PLANNING CONSULTATION RESPONSE

Application No	2026/0357
Proposal	Demolition of existing dwelling and erection of 1no. detached dwelling and garage (Custom/self-build)
Address	Chevara, 179 Sackup Lane, Darton, Barnsley, S75 5AU
Date of Consultation Reply	17/06/26
Consultee	Highways DC

Client:	Ms B Cook	
Project:	179 Sackup Lane Darton Barnsley, S75 5AU	
Drawing:	Proposed Site Footprint	
Date:	Apr 2026	Scale: 1:150 @ A3
Drawing No:	2518/117	Rev:

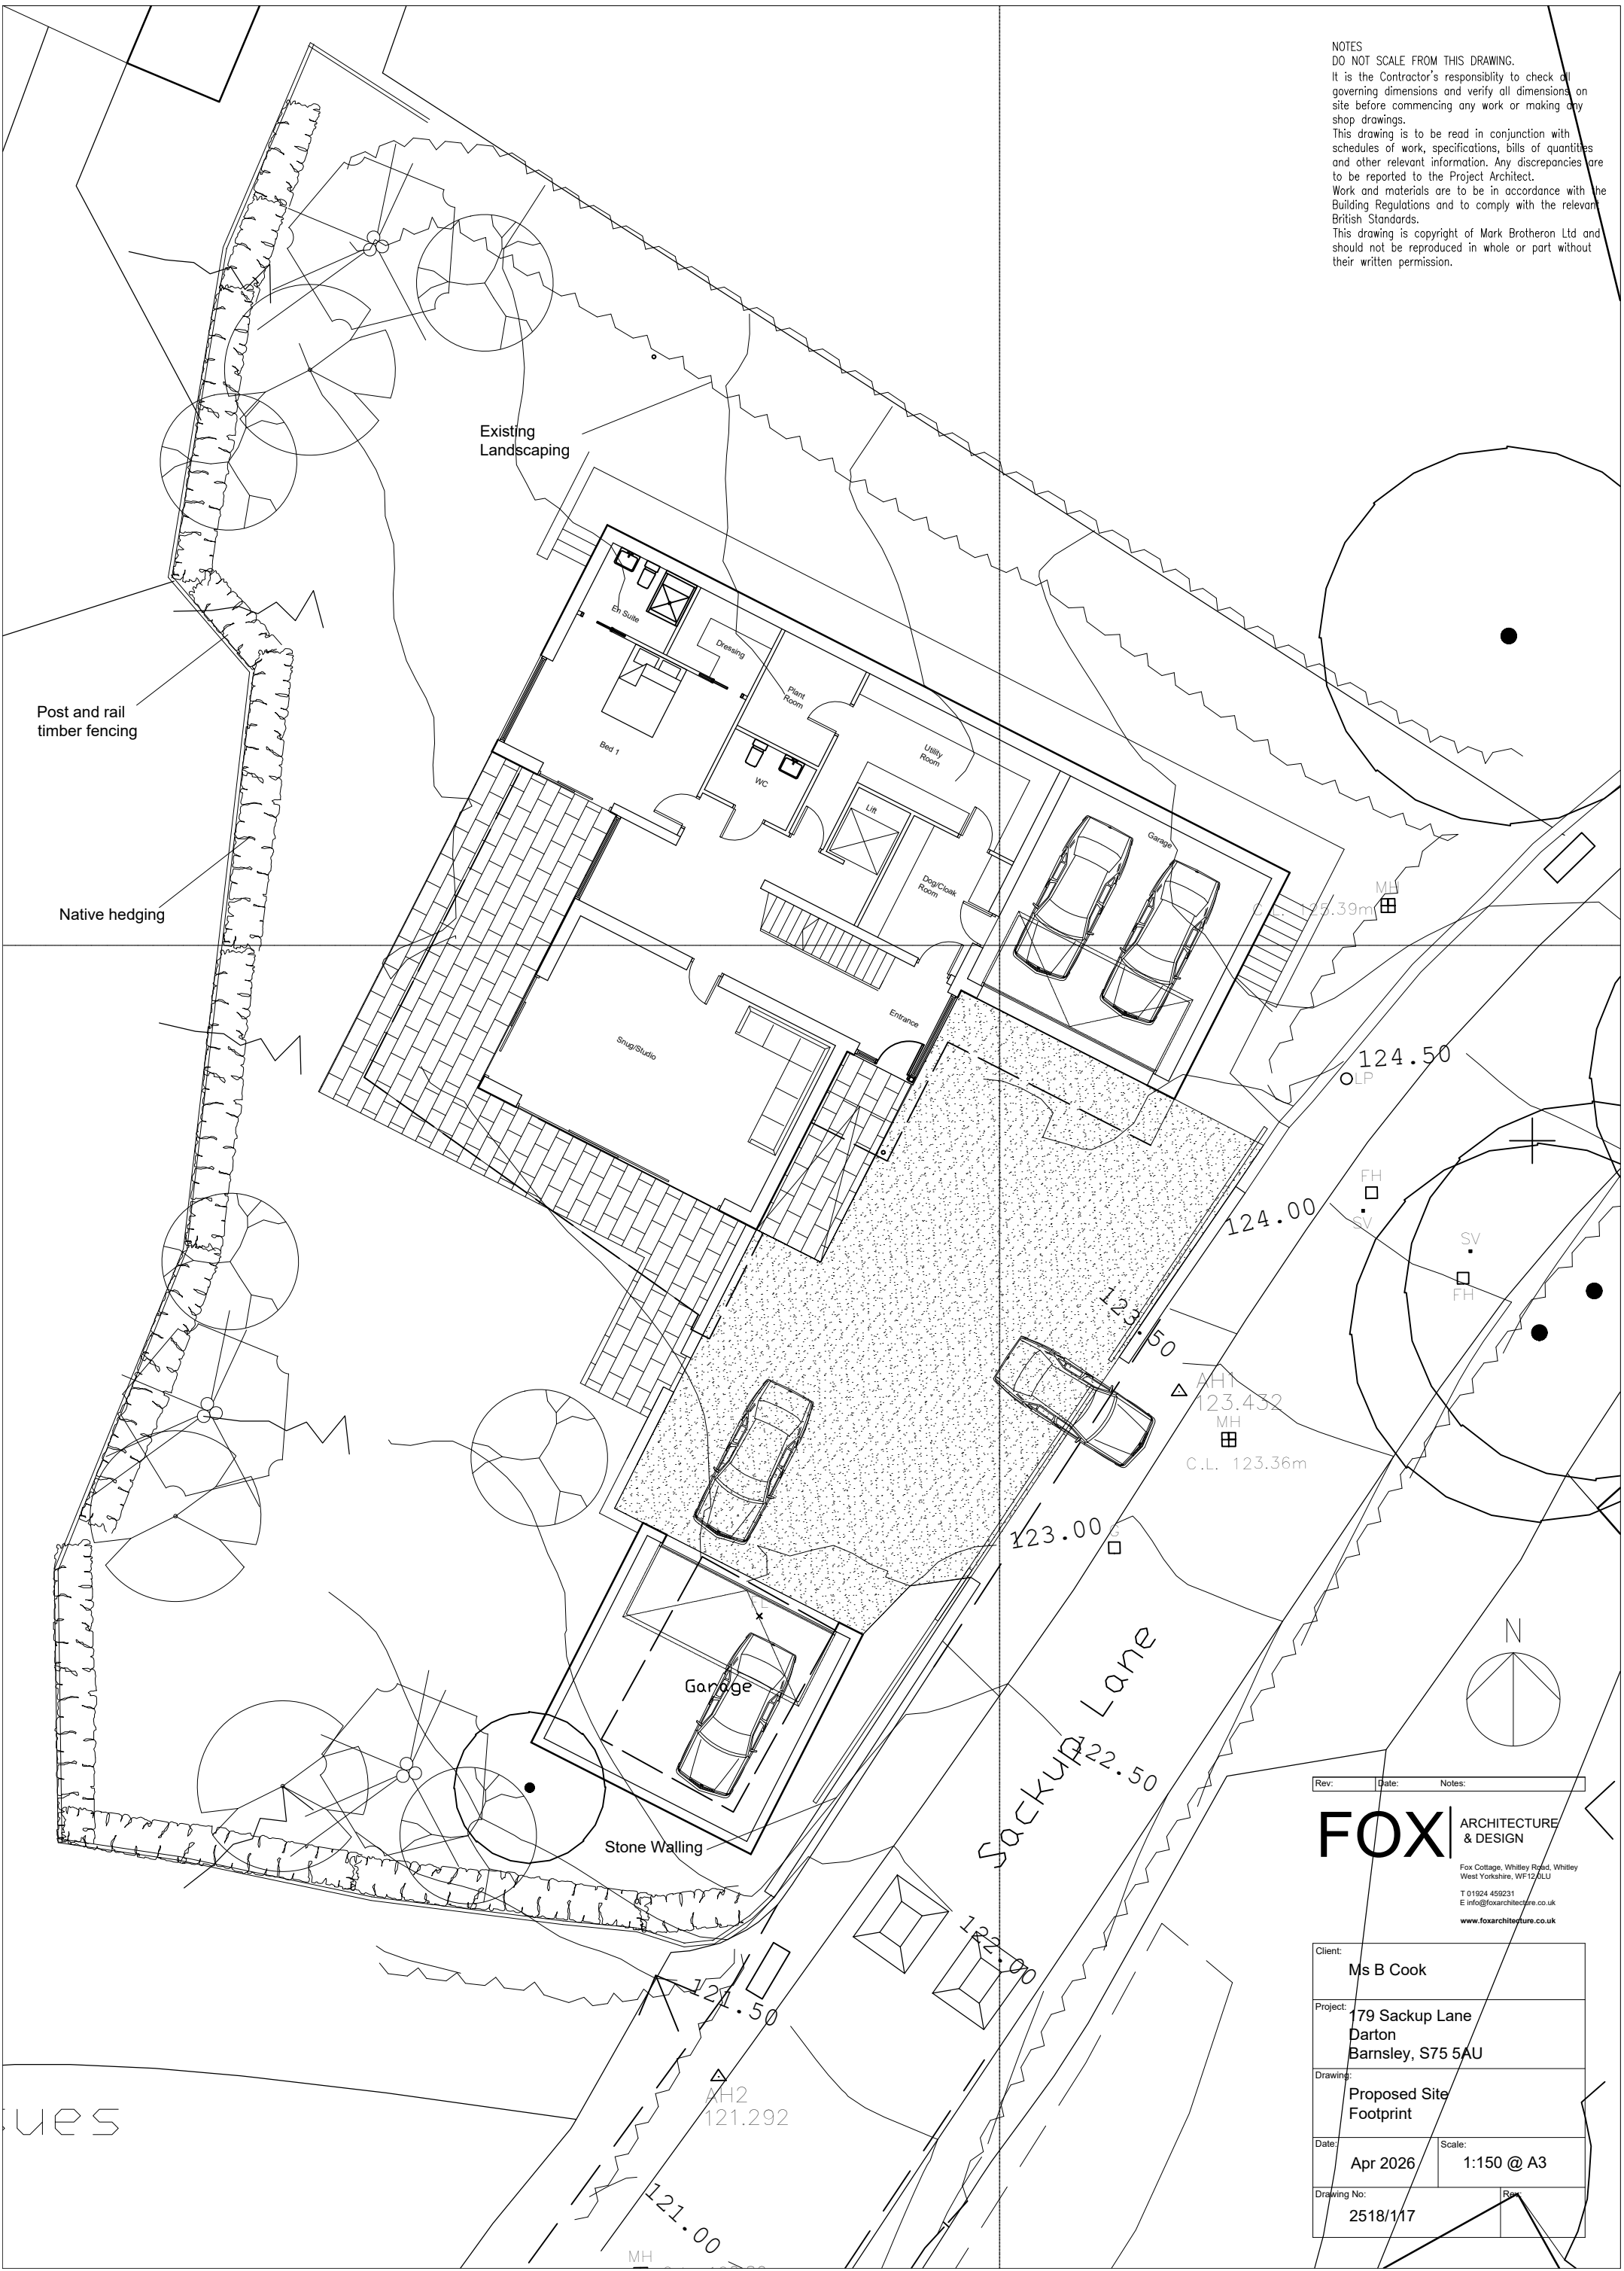
Although the scheme is acceptable from the perspective of highway development control, the Design and Access Statement makes mention that "the exiting vehicular access to the site will be retained incorporated into a new stone boundary wall with a gated access". No details are provided on this construction, but adequate visibility should be maintained from the access onto Sackup Lane. As such, suggested conditions are included below to ensure vehicular and pedestrian intervisibility are satisfactorily retained.

Sight lines, having the dimensions 2.4m x 43m, shall be safeguarded at the access junction with Sackup Lane, such that there is no obstruction to visibility at a height exceeding 1m above the nearside channel level of the adjacent highway.

The parking facility hereby permitted shall not be brought into use until pedestrian visibility splays of 2m x 2m to the back edge of the footway have been provided at the proposed access. Nothing shall be erected, retained, planted and/or allowed to grow at or above a height of 0.6m to the rear of the footway which would obstruct the visibility splays. The visibility splays shall be maintained free of obstruction at all times thereafter for the lifetime of the development.

The parking facilities as indicated on the submitted plan shall be surfaced in a solid bound permeable material (i.e. not loose chippings) and adequate measures shall be so designed into the proposed access to avoid the discharge of surface water from the site on to the highway.
